APPENDIX 2: RESPONSE TO CENTRAL SYDNEY PLANNING COMMITTEE SUBMISSION

Figure 81 Roof penetrations. Demolitions in red and Proposal in blue. Drawing by TZG.

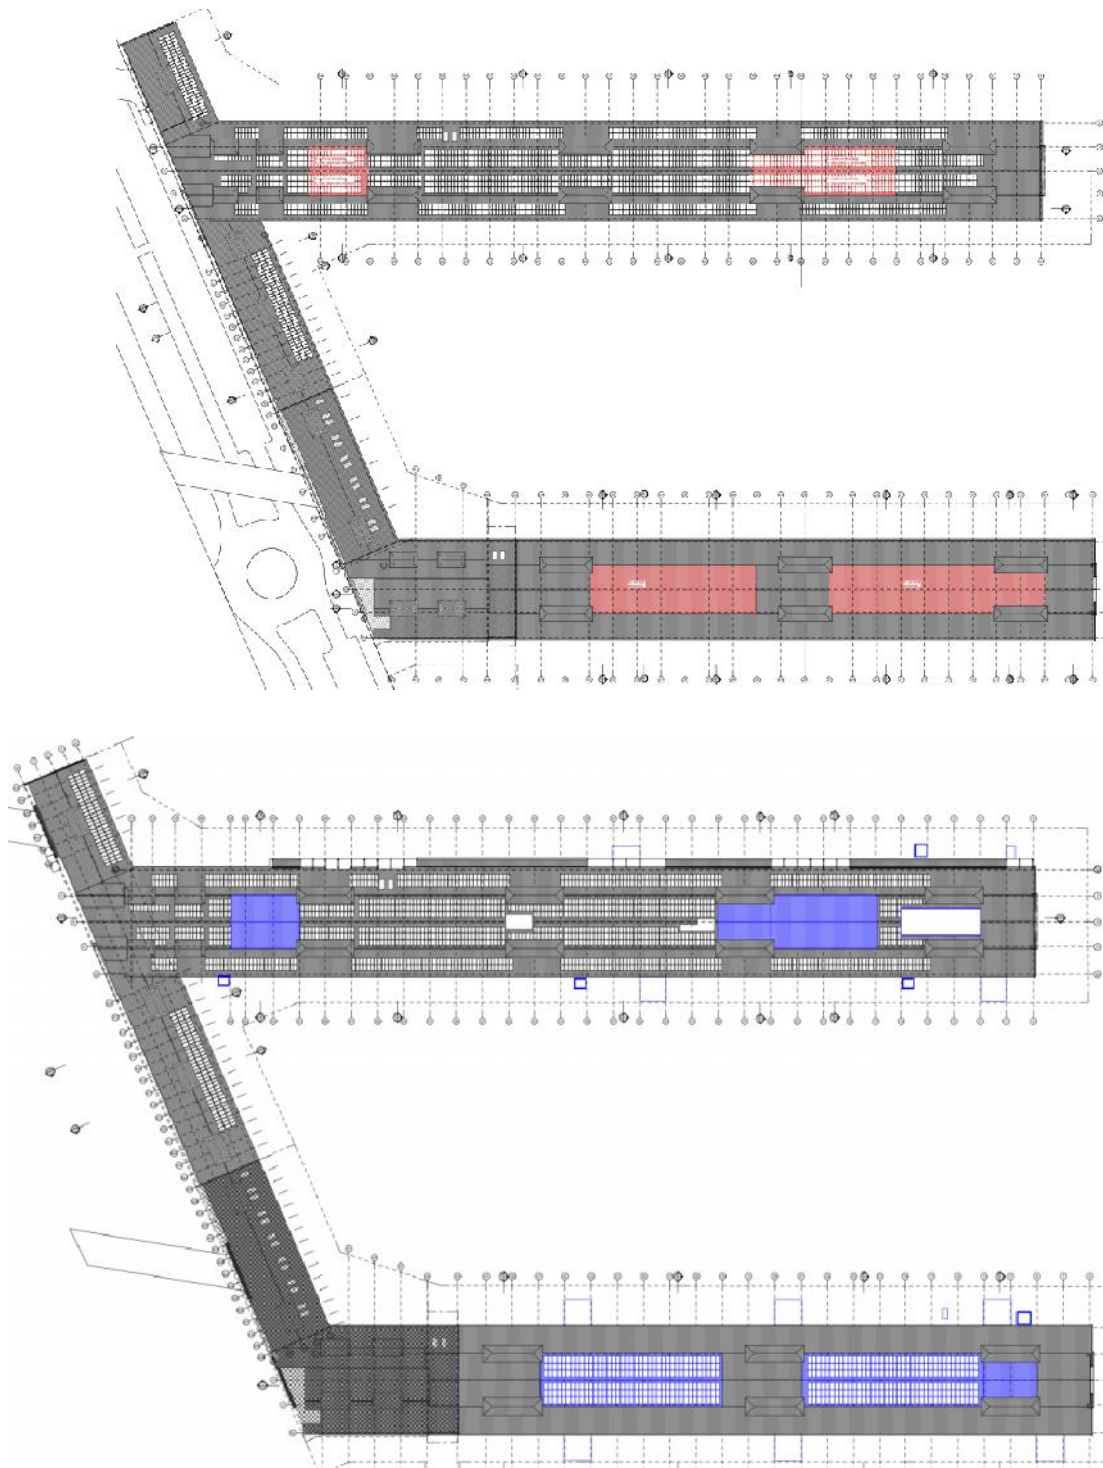
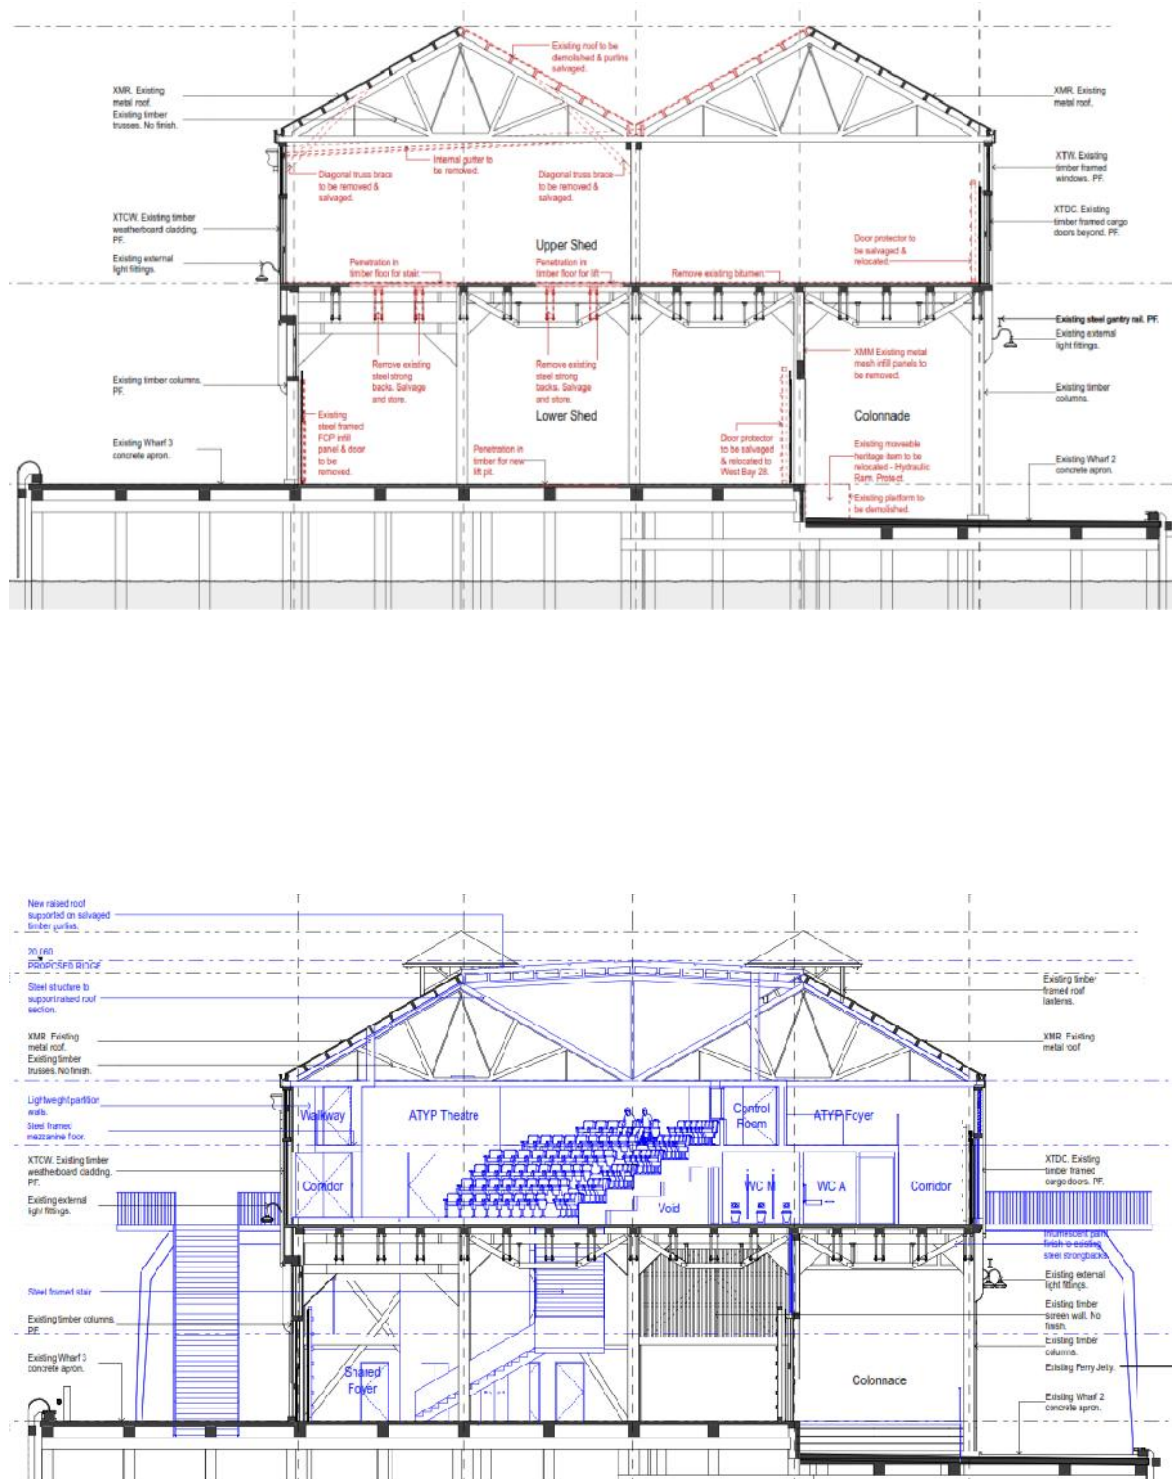
g. The raising of the central roof gutters in sections near the original lanterns should be reduced in their extent so there is separation from the original roof lanterns;	The raised central areas between the roof ridge lines on both Piers have been minimised in the design process. The volume indicated is required to accommodate the internal functions below, which include performance spaces and major mechanical plant rooms, where no reduction in size is possible. This has been repeatedly investigated by all of the design consultants. The extent shown is further required somewhat the supporting structure aligns with the original structural bays and the supporting piles below the wharf deck. As developed in the Richard Lamb View Analysis the proposed extent of roof alterations will not be visible from any significant public viewpoints, and will only obliquely be visible from limited areas such as the SHB cycleway.

Figure 10: Preserve sight lines

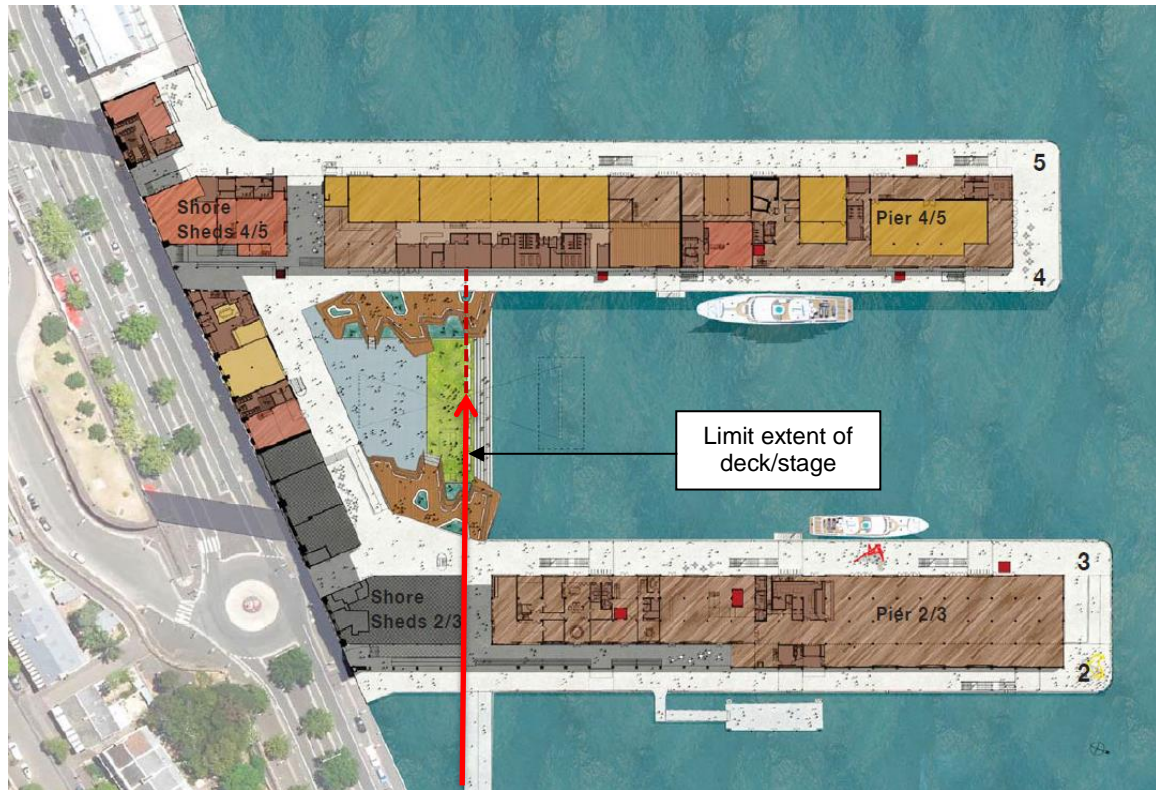
Issue		Response
(a) Urban Design		
	<p>Condition A10 of the Stage 1 consent (SSD 6069) incorporates a series of Urban Design Guidelines to inform the detailed Stage 2 design and redevelopment. The comments below relate to the public domain aspects of the WBAP Stage 2 SSD and consider whether the Stage 1 consent conditions have been adequately satisfied:</p>	
	<p>a. any development of a detailed Stage 2 proposal should not extend in the northerly direction (waterside) beyond the southern side of the Pier 2/3 shore shed 'breezeway' and axis of bridge from Pier 1 to Pier 2/3, their view of the water should not be interrupted by the deck/stage infill. All structures should be contained within a line extending from the face of the Pier 2/3 shore shed.</p>	<p>The design has been amended to ensure the waterfront square deck aligns with the southern side of the Pier 2/3 shore shed 'breezeway'. The lower tidal steps (.ie. those below the mean water mark) will extend beyond this point but will not disrupt pedestrian views to the water.</p>
